DELEGATED DECISION TO DETERMINE PLANNING APPLICATIONS

Reference No:	2025/62/91478/W
Site Address:	land at, Olney Street, Slaithwaite, Huddersfield, HD7 5EG
Description:	Erection of 1 pair of semi-detached dwellings with associated parking and amenity space
Recommending Officer:	Danielle Cooper

Officer Report

- NOTES**
- **Do not scale from this drawing.**
 - This drawing is copyright.
 - All dimensions to be checked on site prior to the order or manufacture of any goods.
- Revisions:**
- A: Red line boundary adjusted June '25
 - B: Roof hipped and internal layout adjusted to suit. Aug '25

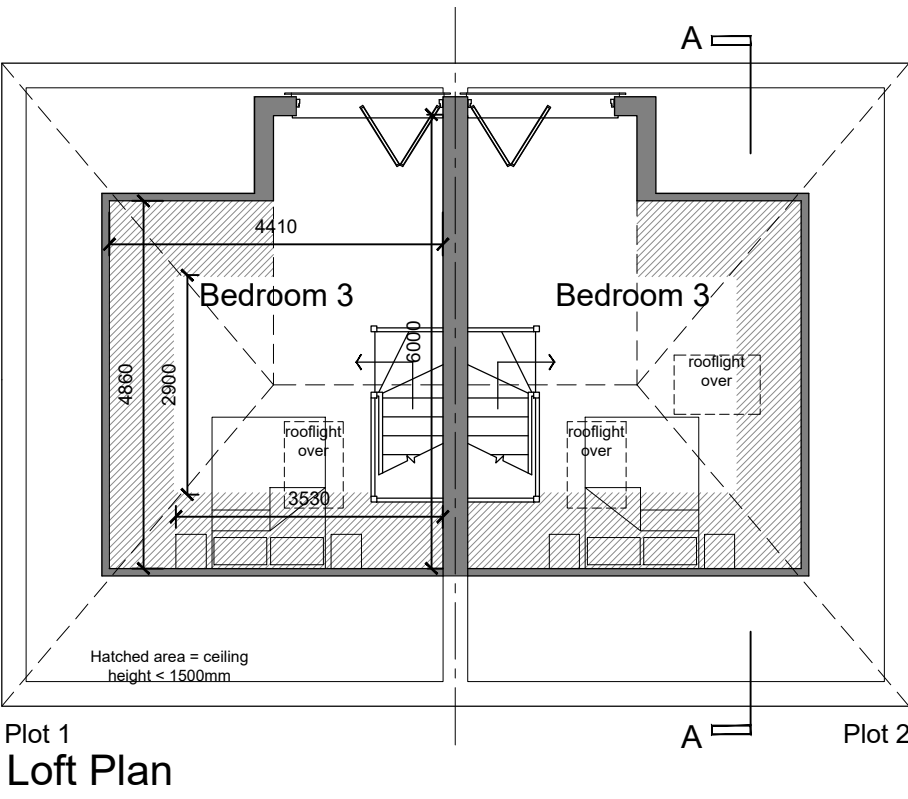
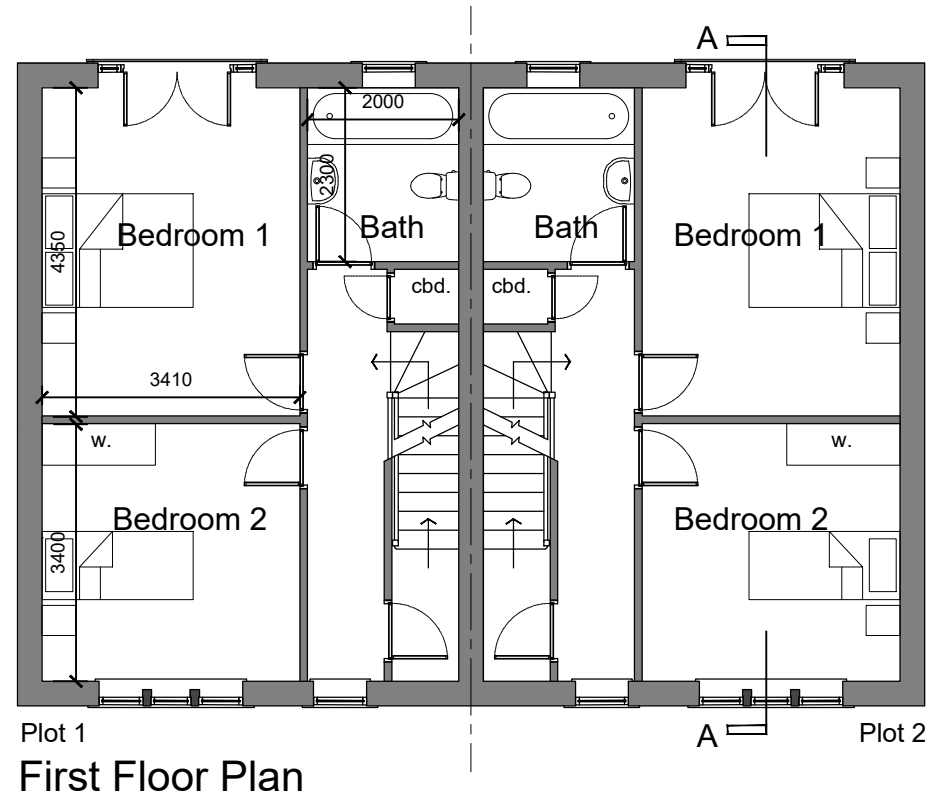
KC Highways Development Management have reviewed the proposal and requested that dropped kerbs, bin storage and collection points need to be shown on plan.

One three-bedroom, and one two-bedroom dwelling are proposed at the site, and the Kirklees Highways Design Guide SPD states that at least 2 on-site spaces are required for dwellings with 2-3 bedrooms. The proposed site plan shows off-street parking provision for two vehicles at each dwelling along the site of the dwelling and as such raises no concern of highway safety. EV charging points also annotated on plan and will be conditioned as such. The proposal also shows two dropped kerbs to access the on-site parking spaces, which will require a Section 184 agreement (Highways) to be entered by the applicant.

Bin storage is shown within the hardstanding area for on site parking which is accepted and bin collection will be carried out to the front of the property on bin collection day which raises no concern.

Revisions:
A: Roof hipped and internal alterations to suit. Aug '25

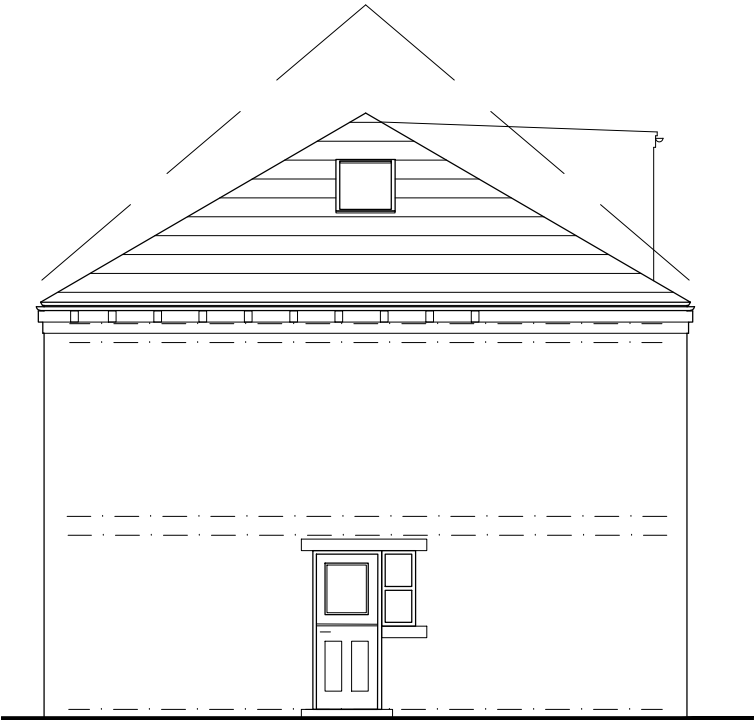
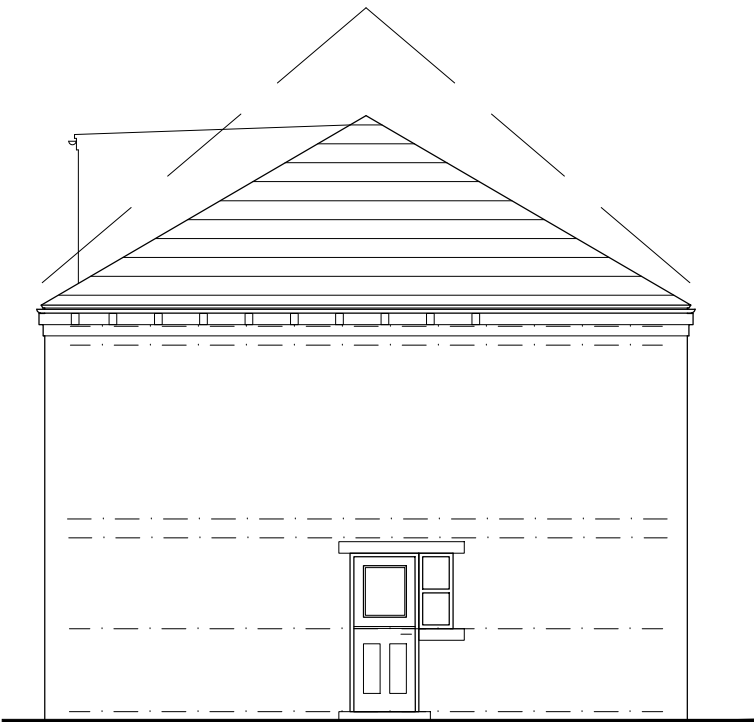
The agent was requested to amend the scheme to reduce the height of the dwellings as concern was raised in regard to the overbearing and overshadowing impact the development as originally submitted would have on the rear amenity space of the adjacent bungalows to the west of the application site.

The proposed dwellings are set in from the shared side boundary with No. 34 and 36 Olney Street by 4.6m and is set away from the rear elevation of these properties by approx. 8.4m. As such, this does not meet the recommended separation distance of 12m contained within the Housebuilders SPD. However, the proposed dwellings have been revised to include a hipped roof form which reduces its overbearing impact. It is also noted that at present there is a tall detached garage situated along the rear boundary of No. 34 which is considered to currently cause an overbearing impact to the residential garden area of No. 34. The proposed semi-detached property would encompass a set off from the shared boundary whilst the existing garage is located almost directly on this. As such, the proposal will provide a buffer of which does not currently exist. It is also noted that this relationship mirrors that of the adjacent bungalow and semi-detached dwelling at No. 12 and 14 Olney Street. As such, it is considered that the impact of overdominance would not be detrimental and is therefore acceptable in this instance.

It is considered that there may be some overshadowing impact to No. 34's rear garden area. However, due to the orientation of the proposed dwellings as well as the generous separation distance, it is not considered that the impact of overshadowing would be significant and is therefore acceptable.

Amended plans were received. These were not re-advertised as the proposed amendments would reduce the impact on the neighbouring occupants and the principle of development unchanged. No neighbour was prejudiced and all and any representations were taken into consideration.
